NORTH FALLS OFFSHORE WIND FARM

**Appendix G3 to Natural England's Deadline 3 Submission**  
**Natural England's Red Throated Diver Compensation Advice on the Applicant's**  
**Deadline 1 Documents**

Planning Inspectorate Reference EN010119

18 March 2025

Figure 2. Long list of potential lochs at which RTD compensation could be implemented in Shetland.

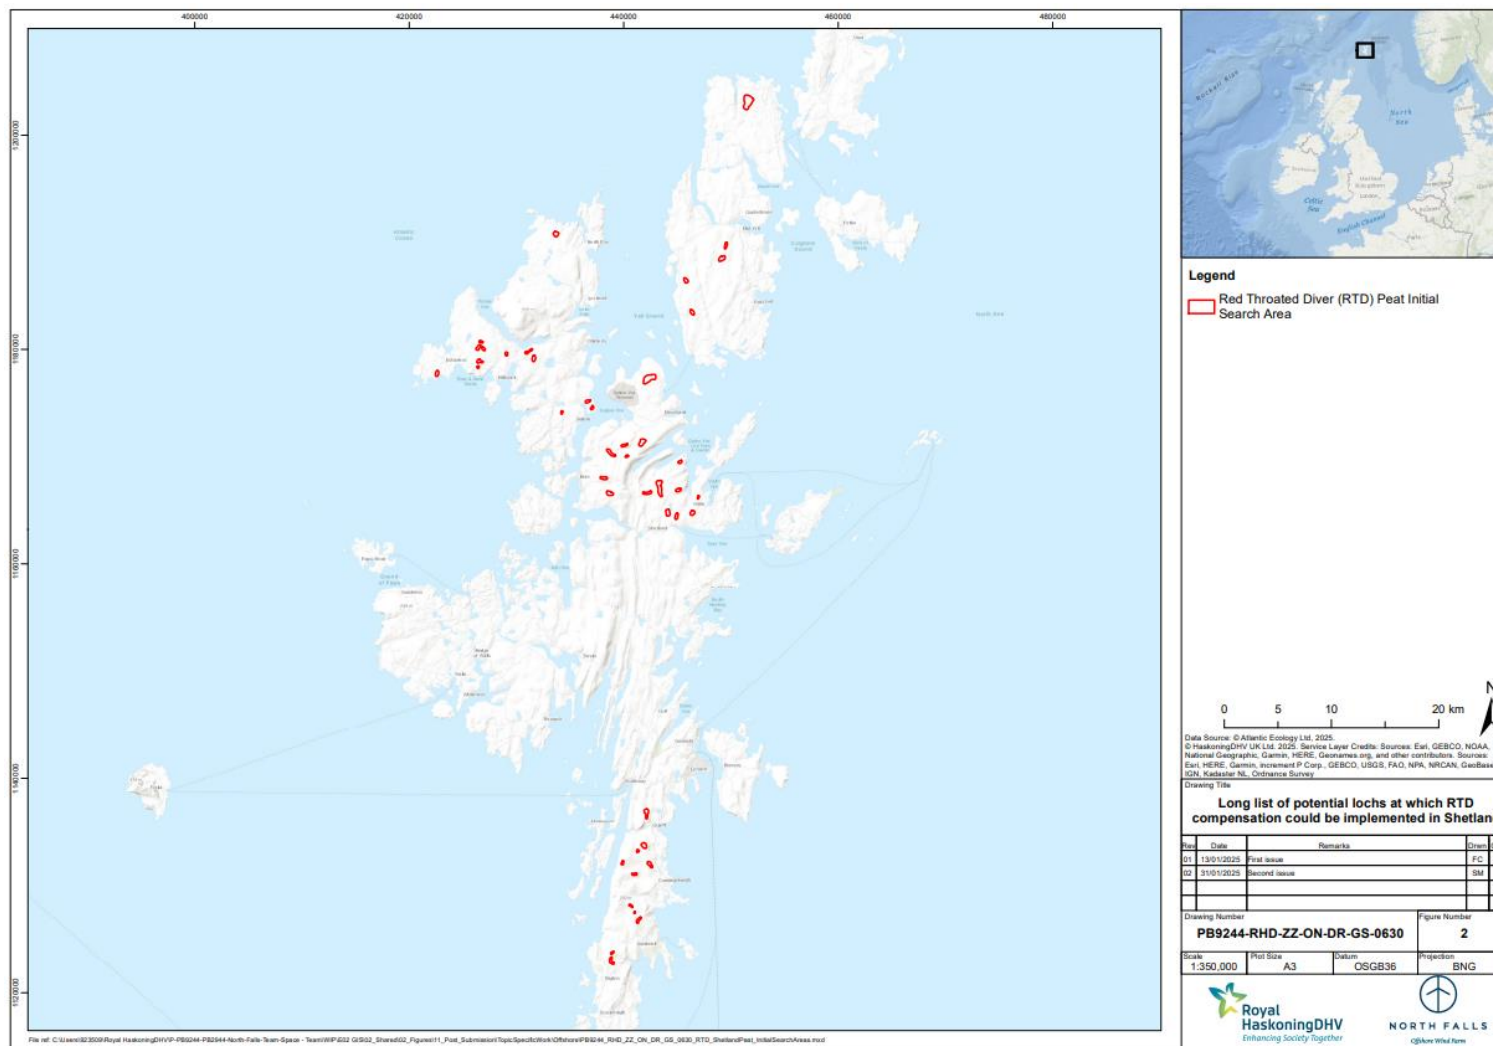
<b>Document reviewed: [REP1-022] North Falls 7.2.3 Habitats Regulations Assessment Appendix 3 Red Throated Diver Compensation Document (Rev 1) (Tracked)</b>			
<b>NE Ref</b>	<b>Section</b>	<b>Key Concern and/or Update</b>	<b>Natural England's Advice to Resolve Issue</b>
1	9.4.2 Para 133	Shetland is not included in the locations identified for long listing in the bulleted list.	We advise the Applicant to correct this text..
2	12.2 Para 158	<p><i>"NFOR has, and continues to, engage with SPR to explore potential collaboration, however opportunities for North Falls to provide additional benefit to the data collection required for the EA1N/2 projects have not currently been identified. NFOR expects to be invited to join a working group being established by SPR and intends to contribute to this group."</i></p> <p>We note that no tangible progress has been made towards securing a suite of measures. It appears that a clear proposal defining actions in collaboration with SPR is increasingly unlikely within the Examination timetable.</p>	<p>Natural England continue to advocate for the delivery of a package of measures.</p> <p>Any progress made towards identifying opportunities for relevant and novel data collection or other actions that could ultimately inform strategic measures to benefit RTD, especially at the impacted site, should be submitted into Examination for review.</p>
